Dangerous Goods Report

Project Title: Toll IPEC Freight Transport Facility
Dangerous Goods

Date: 28 November 2012

This report has been prepared as the result of a review of the initial project drawings and documentation for the Toll IPEC Freight Transport Facility at Eastern Creek in support of the Development Application. The project scope includes recommendations for chemicals including:

**TITLE**  
 SITE PLAN

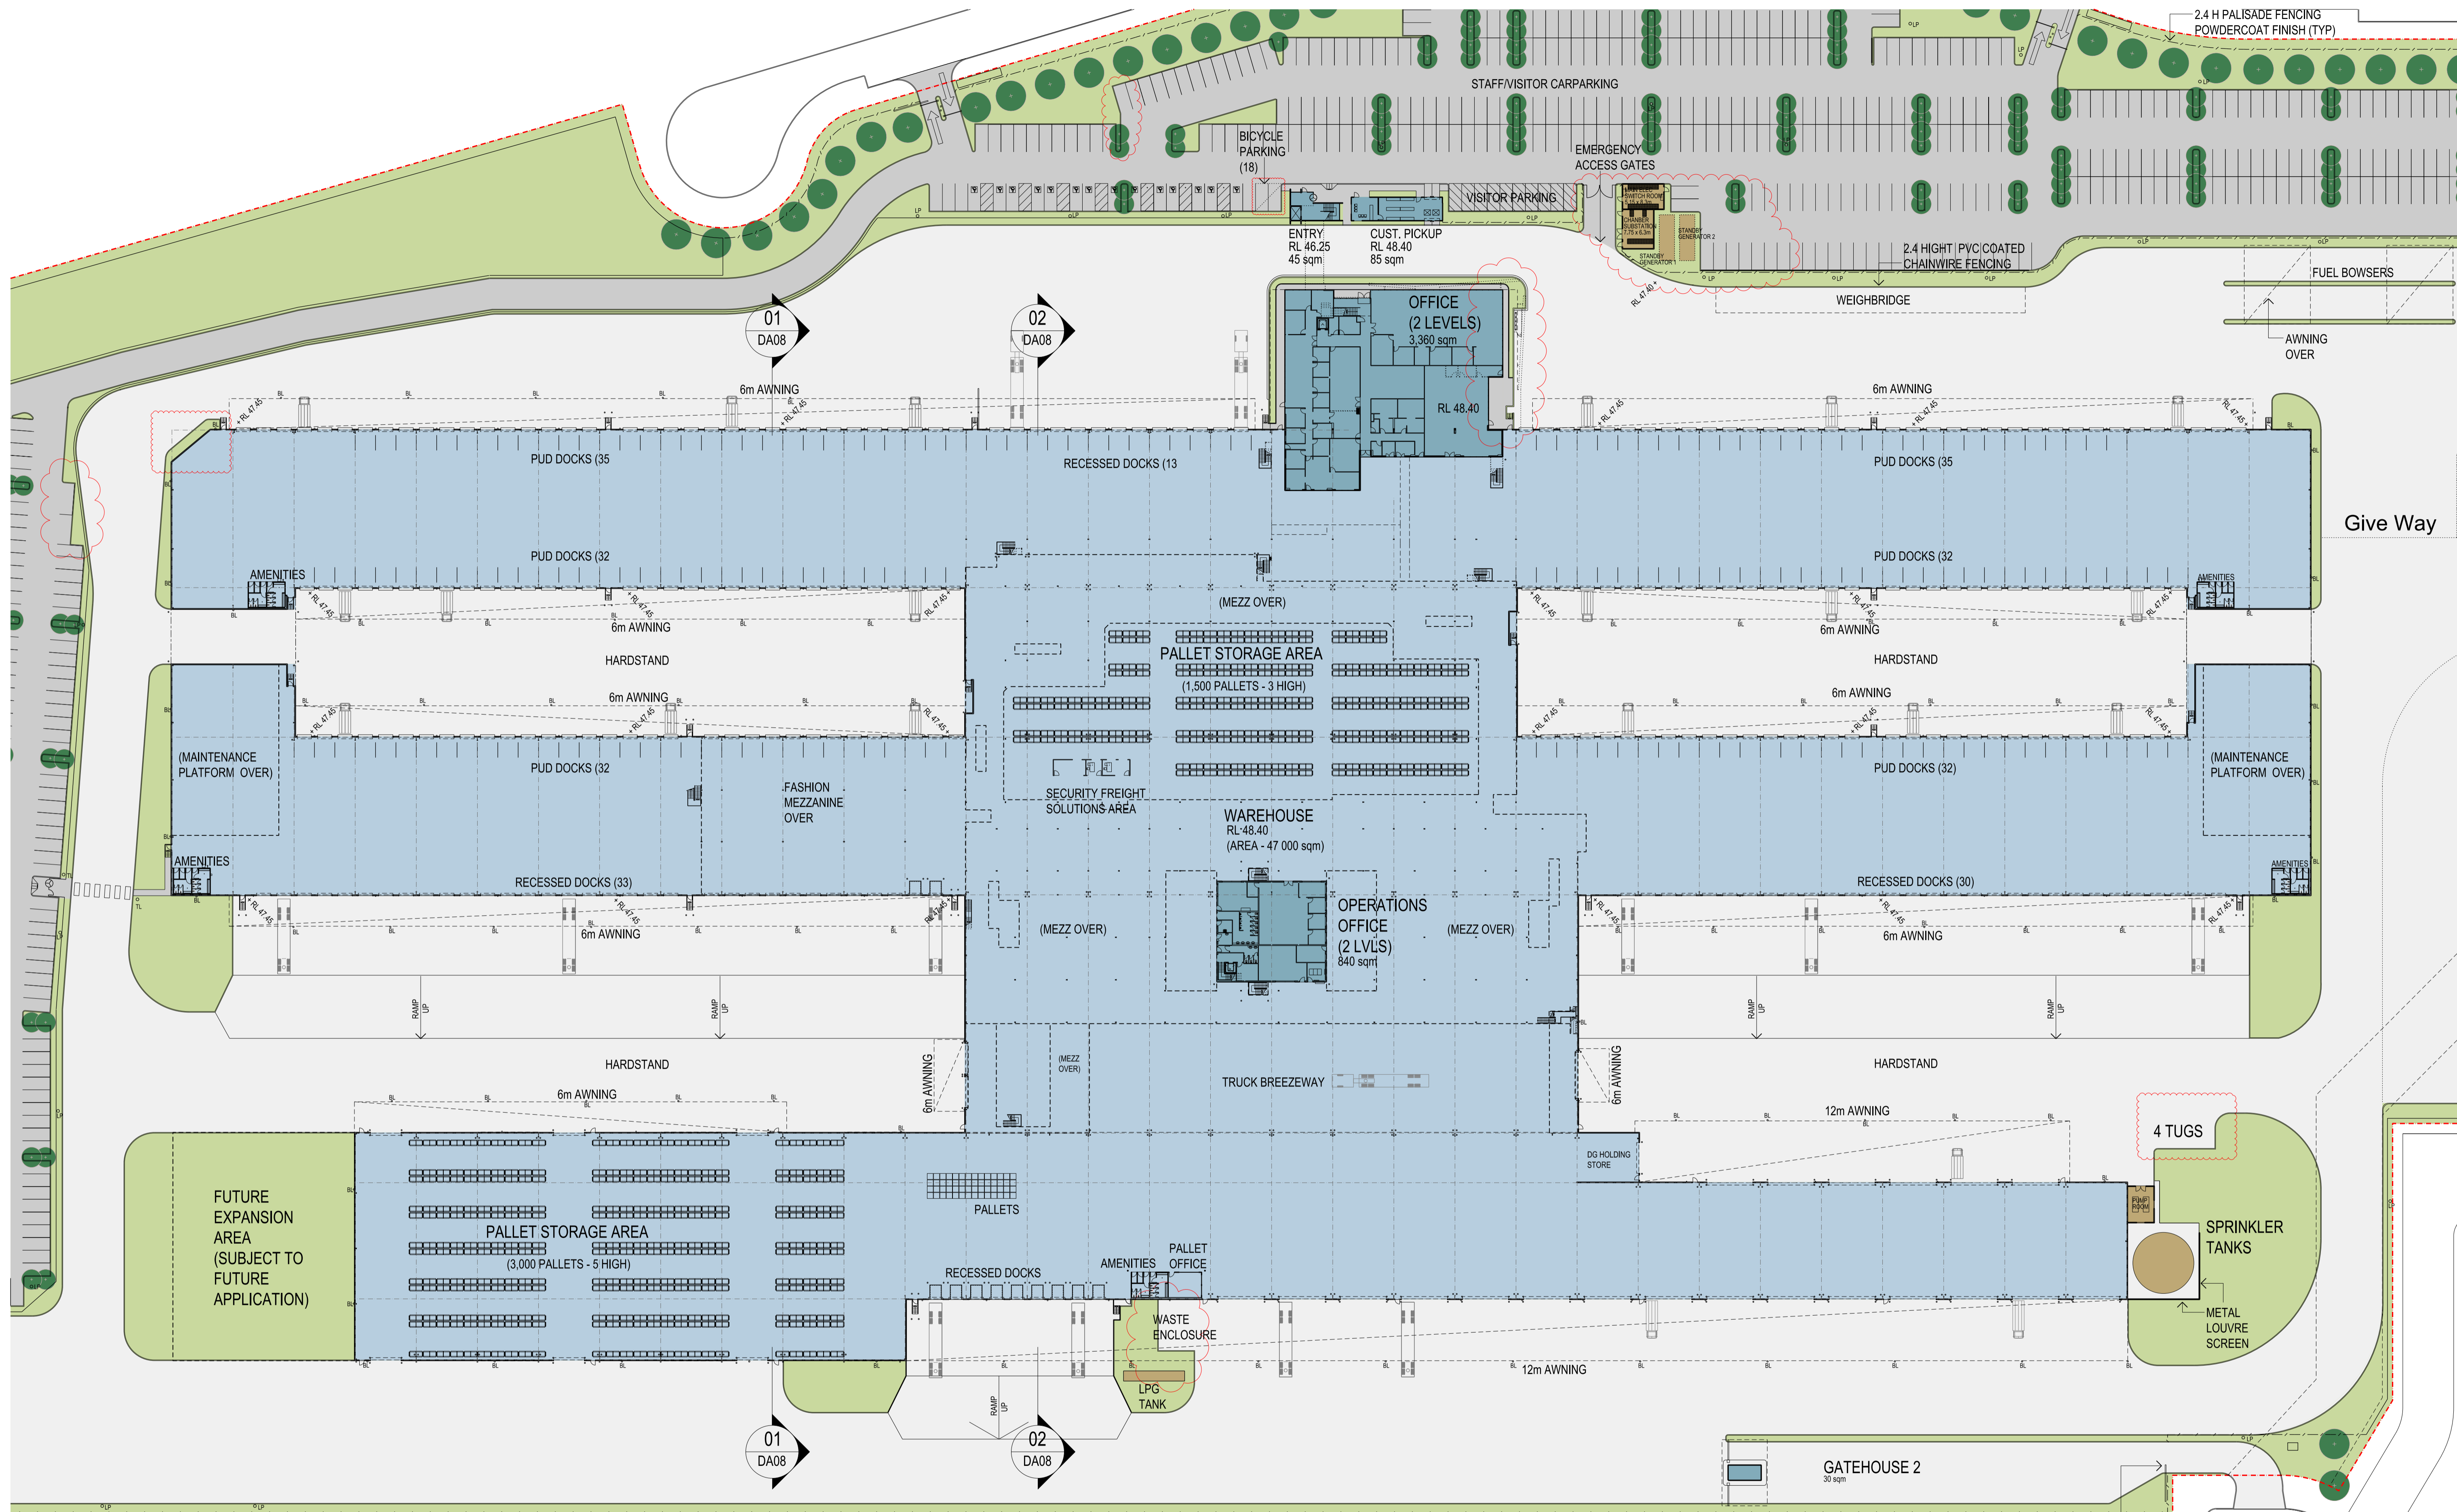
The diesel tanks are marked as end to end. End to end configuration would not be acceptable for petrol, but can be accepted for diesel provided there are isolation valves between the fill point and the tanks themselves.

We still recommend making the tanks side by side if possible. This could be done without getting too close to the fleet workshop.

Tank End Failure	DA-03_E	<p>Bulk fuel tanks should be installed side by side rather than end to end, or where this is not practicable, protection such as a fire rated concrete wall should be provided between the tanks.</p> <p>NOTE:</p> <p>(1) This is especially important if there are bulk petrol or LPG tanks.</p> <p>(2) In practice it is usually more realistic to align the tanks side by side.</p>
Separation Distance – Buildings on site		Bulk fuel tanks in general need to be kept distant from the proposed buildings.
Separation Distance – neighbouring site		Bulk fuel tanks should be kept distant from areas where <i>future</i> buildings could be constructed, even if these are on another site. The best way to manage this risk is to keep the separation distance from the boundary, or to install a fire rated wall.
Separation Distance – between tanks		<p>If bulk LPG tanks are the same size and type, separate from each other by the tank diameter.</p> <p>Bulk diesel tanks should be separated by at least 600mm.</p>

Separation - internal	DA-03_E	Dangerous Goods storage areas should not be against the walls of offices or other areas where people may gather (e.g. meeting rooms), or stringent fire rating may be required. Separation by distance can address this risk, particularly in a large facility if the core purpose is not DG storage.
Gas generation – Battery Charging	DA-09_C	If hydrogen is expected to be generated, even in small quantities, in recharge areas we recommend that the ceiling slope up slightly to a vent, to prevent dangerous accumulation of lighter-than-air flammable gas. Spark generating equipment should be kept clear of battery recharge areas.
Incompatible chemicals		Some batteries contain sulphuric acid which is corrosive and will react violently with some chemicals. It is recommended that no other chemicals be stored in, or used in, recharge areas where such batteries are charged.
Ignition Source – Battery Charging		Sealed concrete floors generate significant static charge. It is recommended that where bottle gas is stored, the floor be unsealed concrete.
